**SUNDERLAND CITY COUNCIL'S RESPONSE TO THE DRAFT
DEVELOPMENT CONSENT ORDER – DOCUMENT REFERENCE SCC 1**

DCO PROVISION	COMMENT
2. "the engineering drawings and sections"	<p>The following drawings submitted by the applicant as part of this DCO submission have been reviewed by SCC.</p> <p>It is noted that the drawing status is to support the application, and as such are not full detailed design drawings.</p> <p>The drawings listed below are considered acceptable in principle. However, comments are provided below to assist with future design and drawing revisions.</p> <p>Location Plan: TR010024/APP/2.1 Rev 0 Scheme Layout Plan: TR010024/APP/2.2 Rev 0 Engineering Drawings and Sections: TR010024/APP/2.6 Rev 0</p> <p>Engineering Drawings - Highways General Arrangement – APFP Regulation 5(2)(o) – Sheet 1 of 2, TR010024/APP/2.6.1(A)</p> <p>Engineering Drawings - Highways General Arrangement – APFP Regulation 5(2)(o) – Sheet 2 of 2' TR010024/APP/2.6.1(B)</p> <p>Engineering Drawings - Highways Longitudinal Sections – APFP Regulation 5(2)(o) – Sheet 1 of 3, TR010024/APP/2.6.2(A)</p> <p>Engineering Drawings - Highways Longitudinal Sections – APFP Regulation 5(2)(o) – Sheet 2 of 3, TR010024/AP

Drawing title **ENGINEERING DRAWINGS STRUCTURES DRAWINGS & SECTIONS NON-MOTORISED USER OVERBRIDGE REGULATION 5(2)(o) & 6(2)**

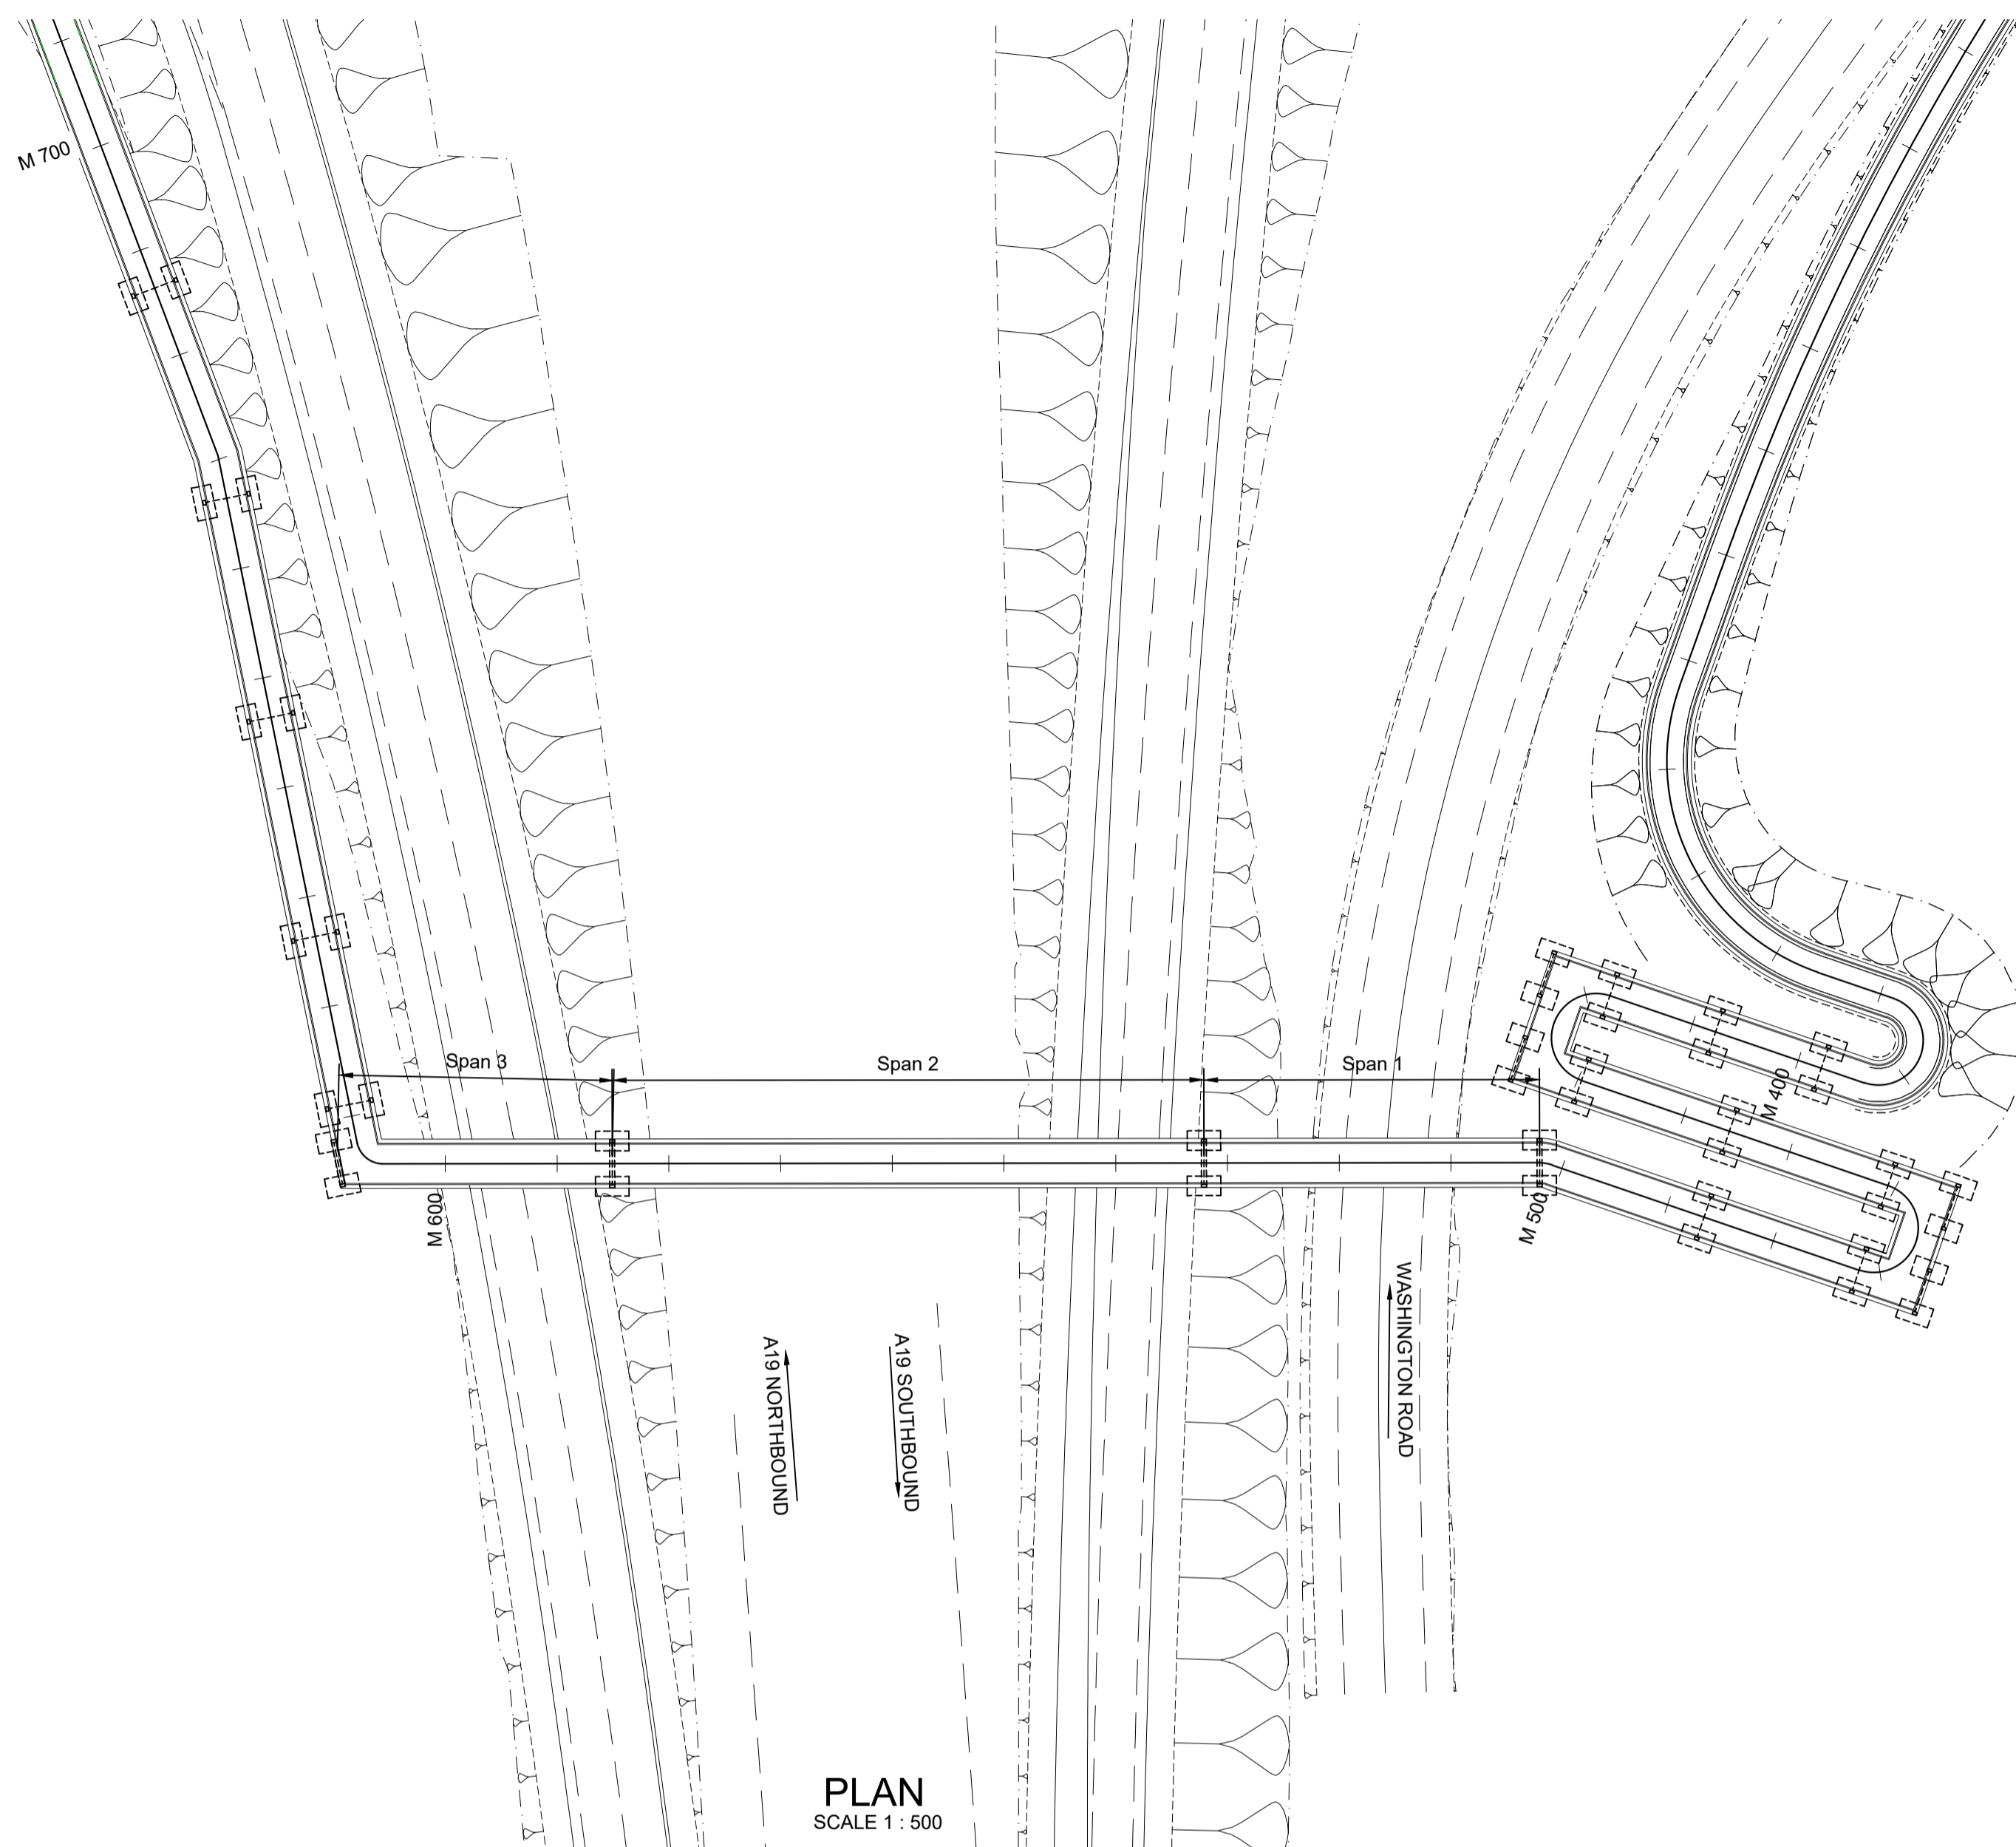
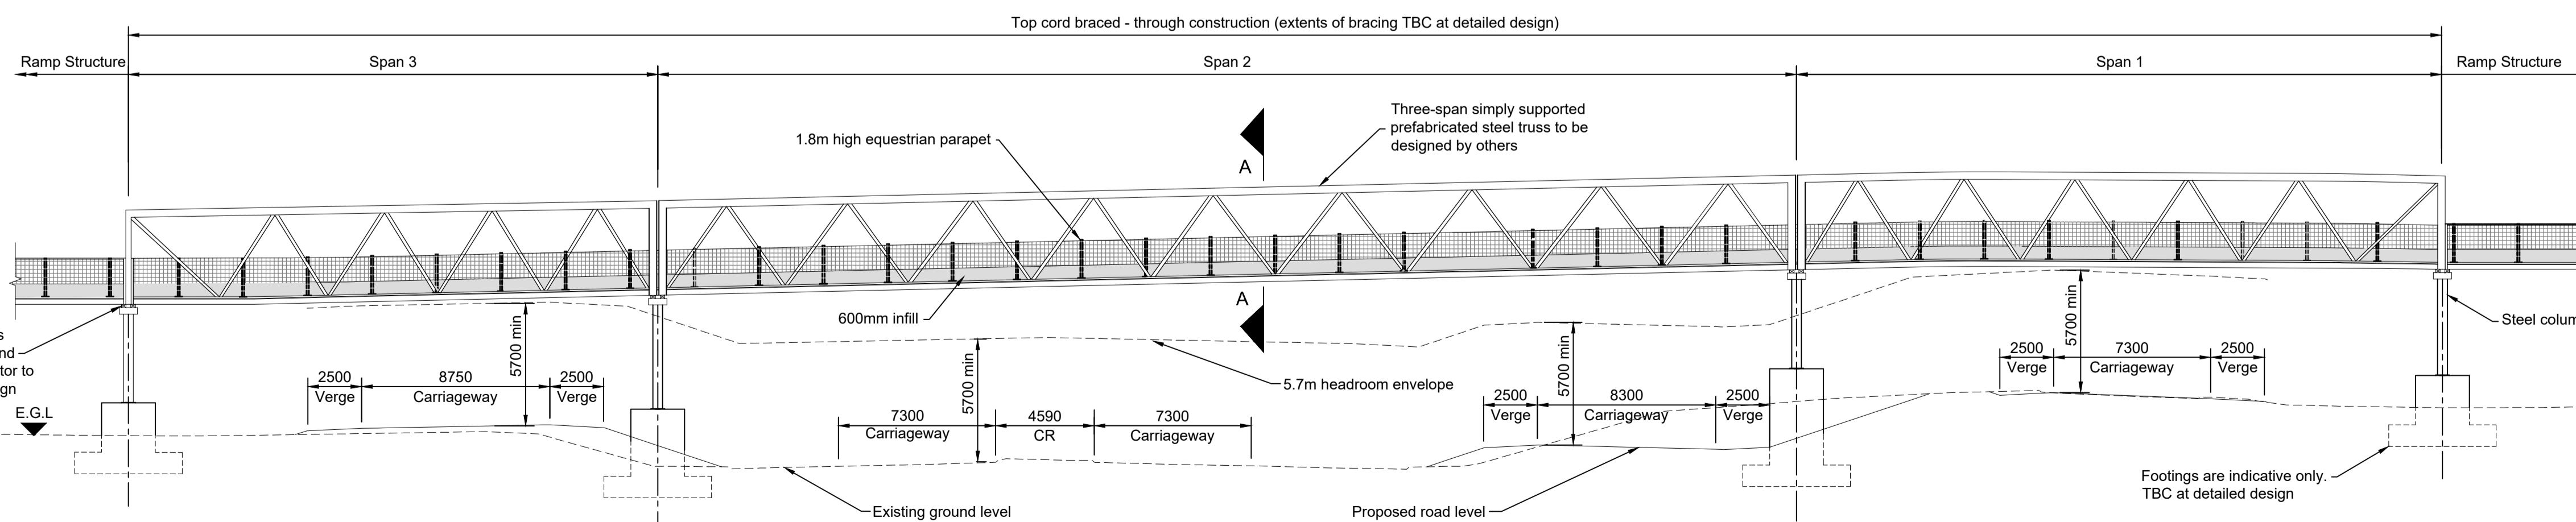
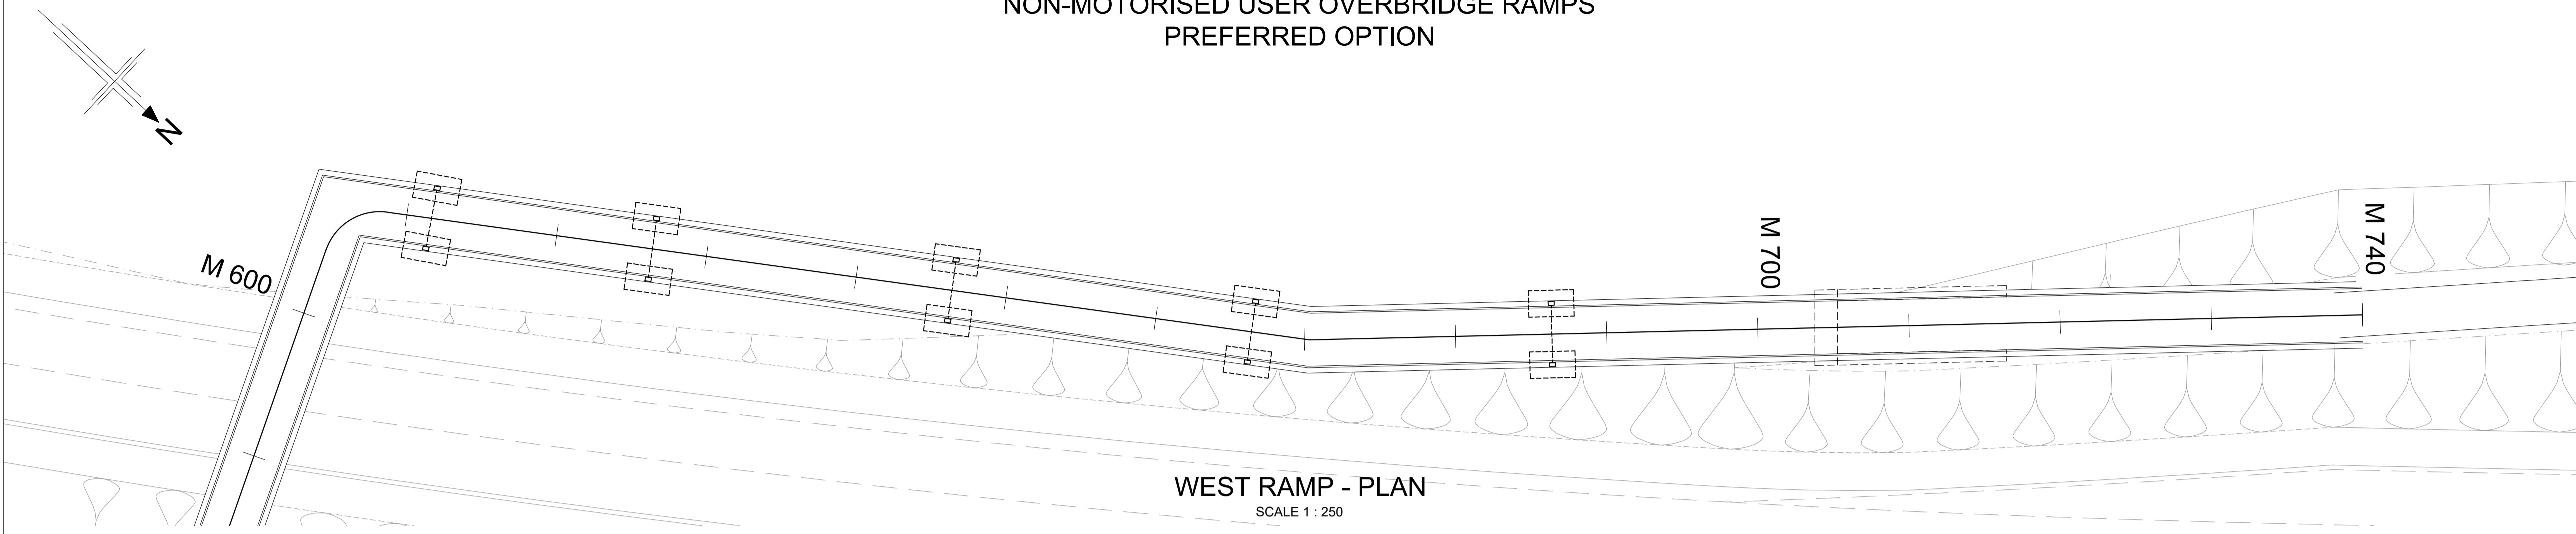
<p>Engineering Drawings - Structures – South Junction Overbridge – APFP Regulation 5(2)(o), TR010024/APP/2.6.3(A)</p> <p>Engineering Drawings – Structures – Non-Motorised User Overbridge – APFP Regulation 5(2)(o), TR010024/APP/2.6.3(B)</p> <p>Engineering Drawings – Structures – Non-Motorised User Ramps – APFP Regulation 5(2)(o), TR010024/APP/2.6.3(C)</p> <p>Engineering Drawings – Drainage General Arrangement – APFP Regulation 5(2)(o), TR010024/APP/2.6.4</p> <p><u>SCC Comment 1 - New south junction overbridge –</u> Highways England to be responsible for the bridge structure. STC to be responsible for future maintenance of road surfacing on the circulatory carriageway and eastern approach roads on local road network. This also applies to street lighting and traffic signals.</p> <p><u>SCC Comment 2 - Non-motorised user preferred option (based on current DCO application) and approach mu routes –</u> It is noted that the span provides a 3.5m route clear of obstacles and 1.8m parapet protection to both sides, which is acceptable for NMU provision (pedestrians, cyclists and equestrian users).</p> <p><u>SCC Comment 3 - Based on the current DCO proposal for the Non-Motorised User Overbridge –</u> Highways England to be responsible for the bridge structure. This should also apply to the waterproofing system and surfacing as it appears to be an integrated solution</p>
